Epping to Thorleigh Third Track proposal

Your submission

Figure S.6 Cross-section and elevation - New Cheltenham Station concourse building (see also S.5 for artist's impression)

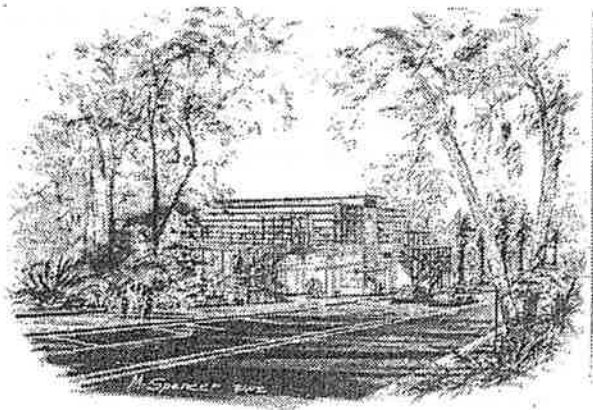
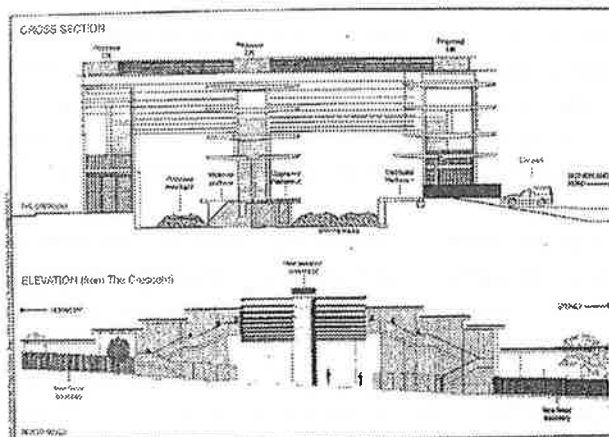
The modern design height of buildings for the station at Cheltenham is totally out of character for this area which contains many heritage features.

If the station has to be reconstructed, it should be designed to compliment the area rather than be in direct conflict with the surroundings.
